**KITTITAS COUNTY COMMUNITY DEVELOPMENT SERVICES**

**Subject:** LPF-21-00001 Pass Life Origins Final Plat – Staff Review, Request for Additional Information.

Kittitas County Community Development Services (CDS) received your LPF-21-00001 Pass Life Origins Final Plat submittal on February 17, 2021. Kittitas County staff have completed a review of your final plat submittal. As provided below, staff has the following comments, requirements, and/or revisions for your application that need to be addressed prior to final approval and signature of the final plat mylars:

LPF-21-00001

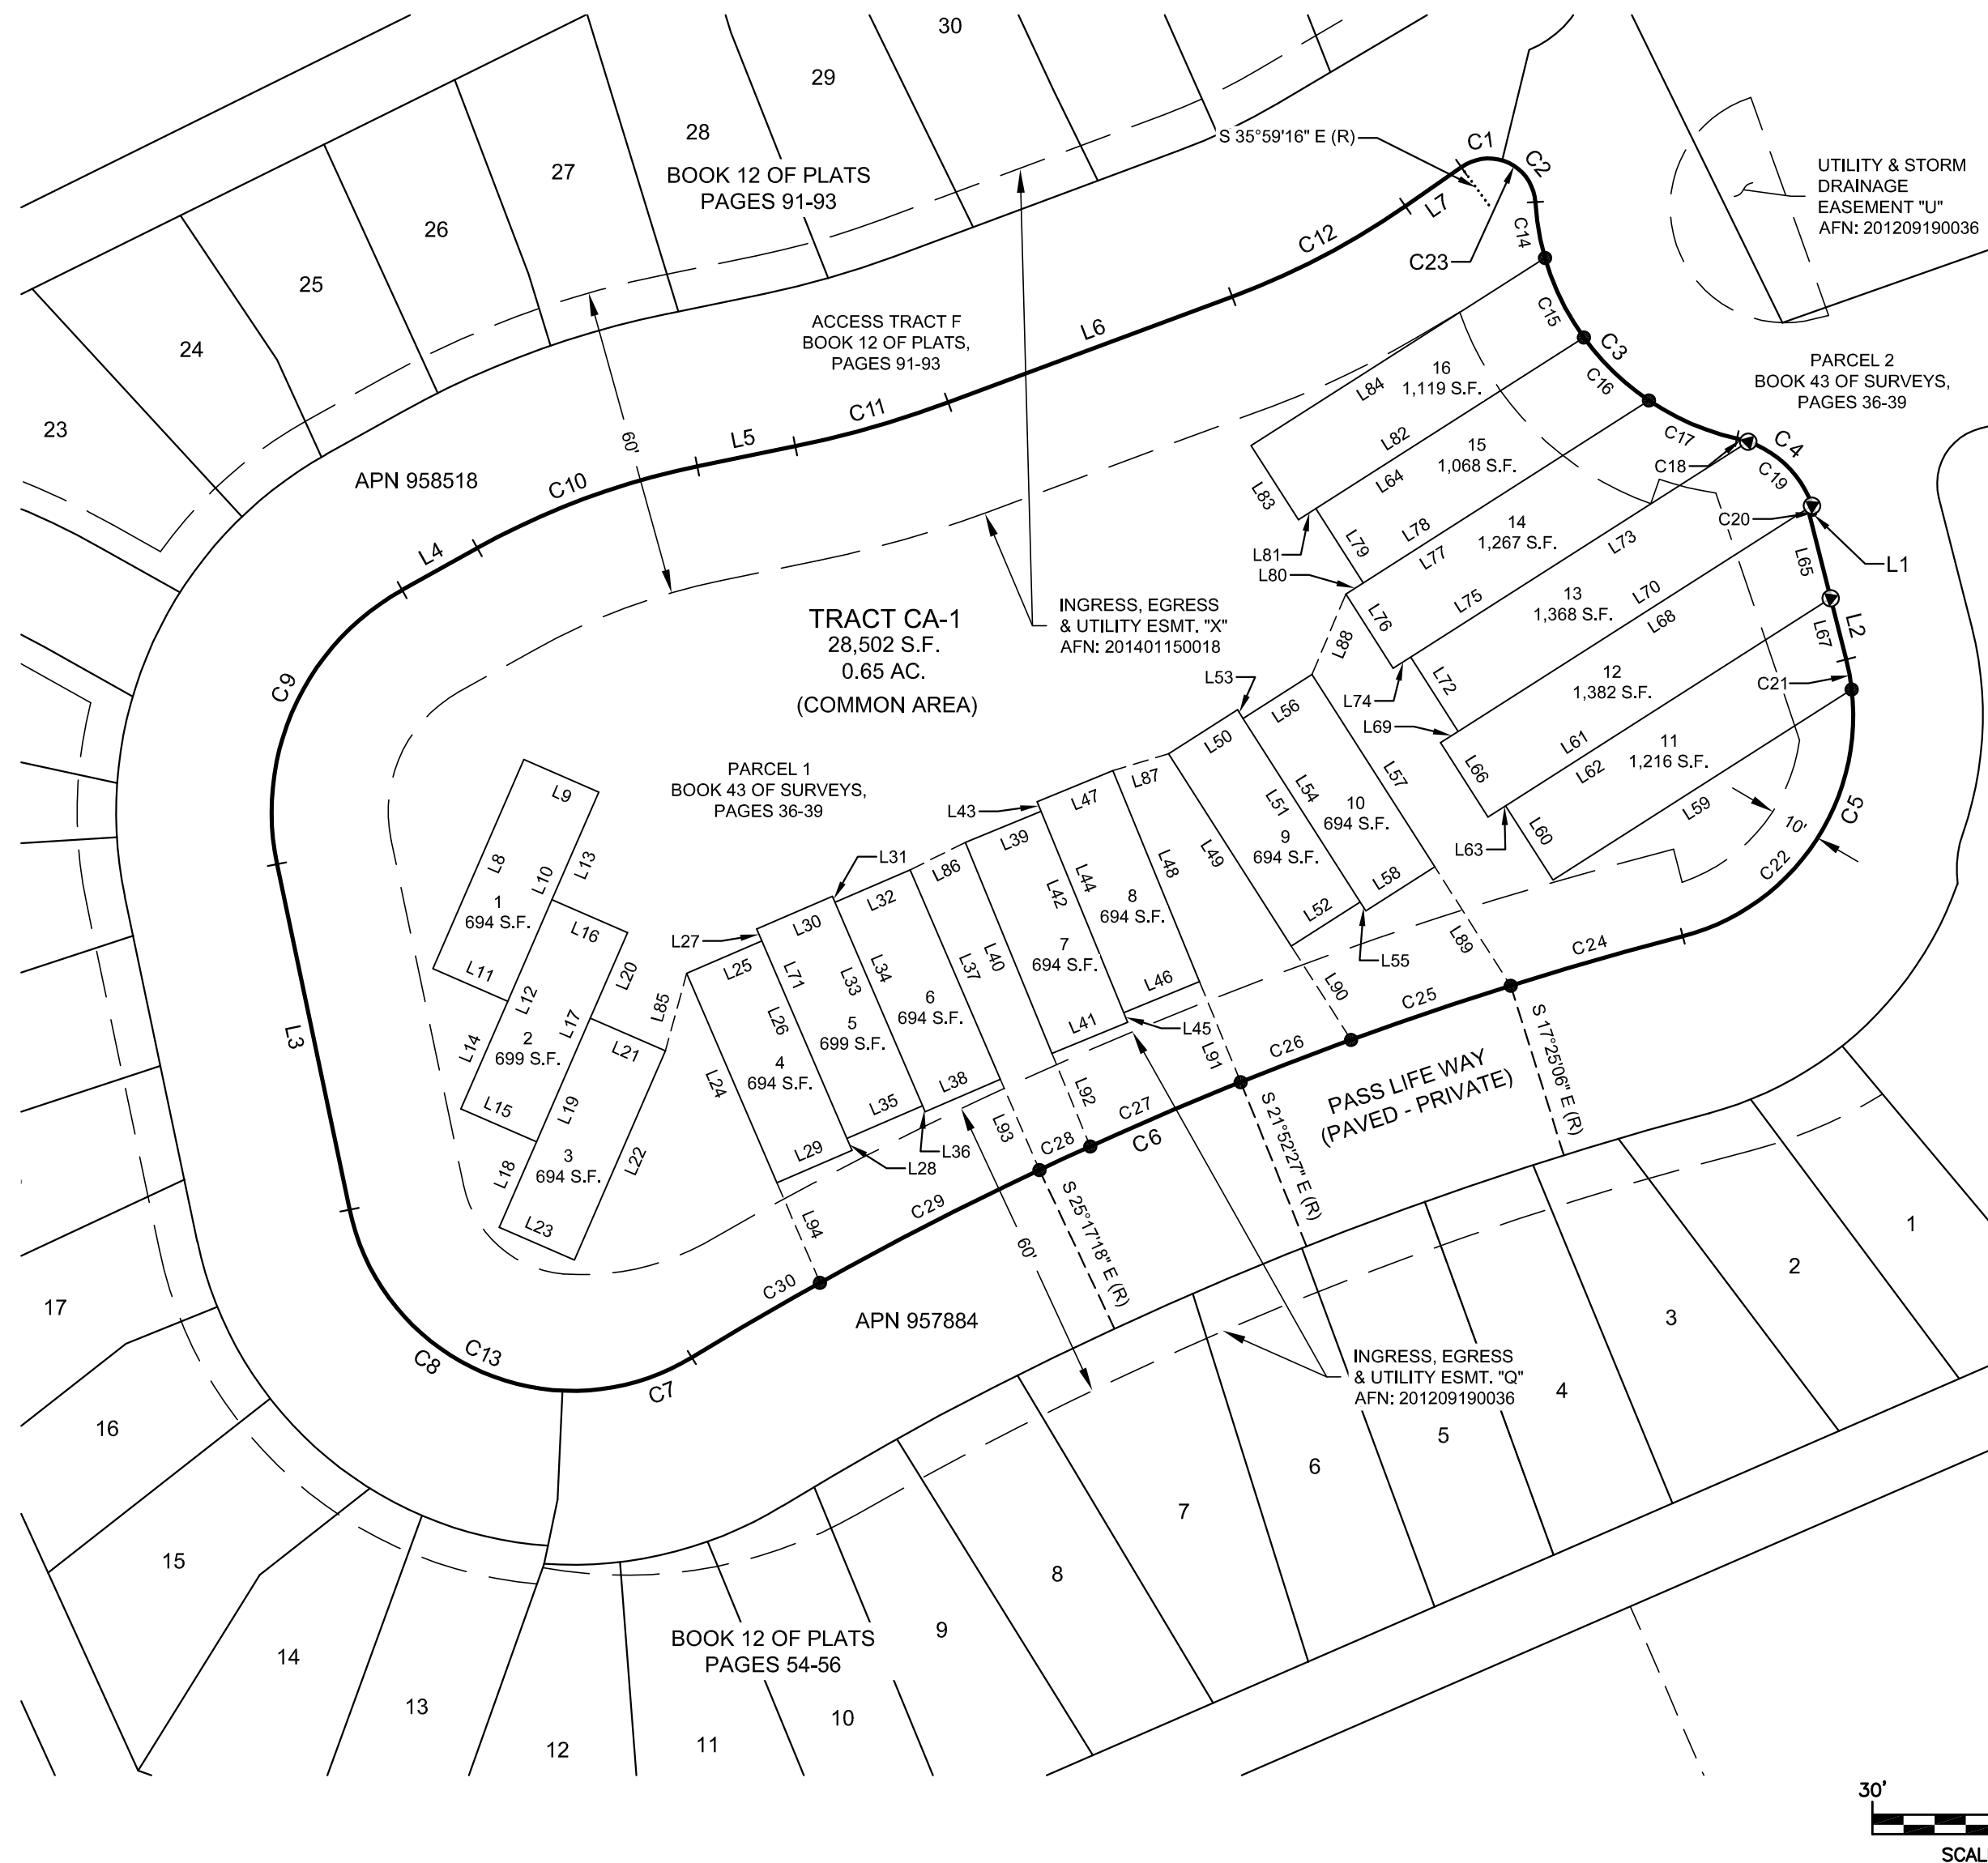
- The final mylars shall note the final plat file number LPF-21-00001 on the face of the plat.
- Taxes on parcel #957885 must be paid in full before final signature.
